Final Report - Corrections Required
Application No. LUPL-25-0008

RE: EPC Comments – BLR Village C Rezone (ZONE-25-0020)

On behalf of Clayton Properties Group II, A Colorado Corporation DBA Oakwood Homes, we respectfully submit the following responses to the review comments dated July 09, 2025.

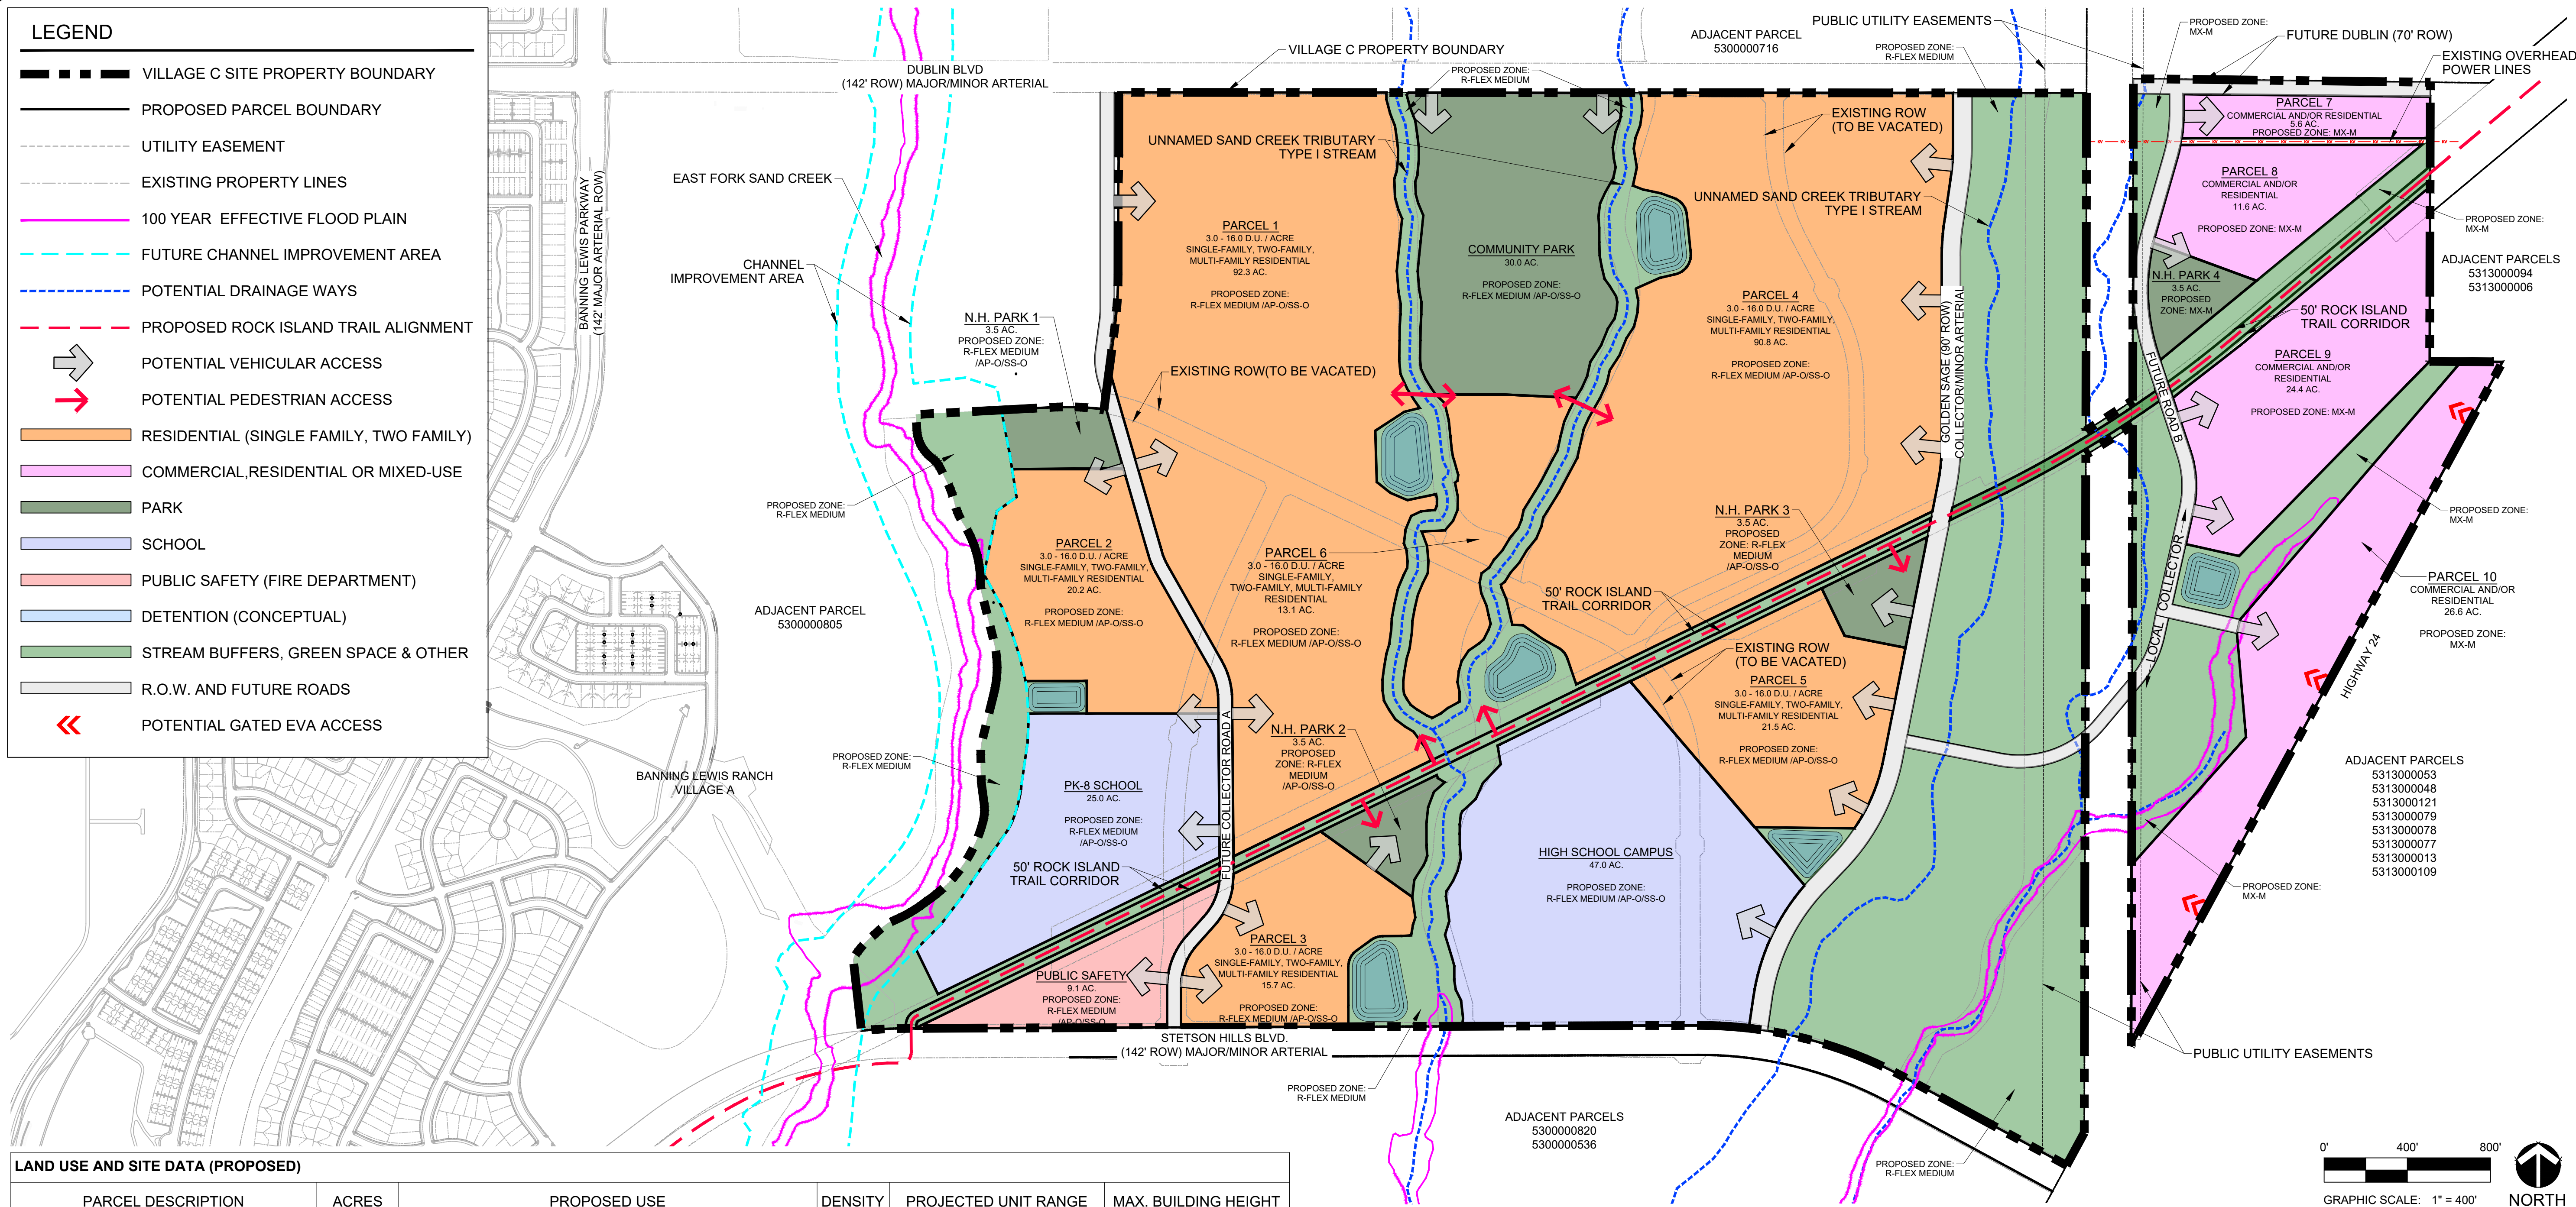
1. Note: Coordination is needed between the developer, the City and EPC (DPW and Parks) regarding the Dublin Blvd./Falcon Highway alignment. See attached sketch/redlines.

[Response: Coordination is on going. Current direction per meeting on 9/8/2025 with Jeff Rice, Todd Frisbie and development team is that BLR Village will dedicate at a future plat 70' to the ROW of a future Dublin ROW with a 5' easement and an additional 30' will need to be provided from adjacent land owner or through city annexation or another method for 100' Minor Arterial through this area.](#)

2. Is future access (secondary) for the Falcon Meadow Campground parcels being accommodated?
(Reference US HWY 24 Access Control Plan)

Response: No access to the campground has been requested, current direction is they will have their own access off Highway 24. CDOT has mentioned being accommodatable to emergency gated access from highway 24 as well. Land Use plan only shows major roadways.
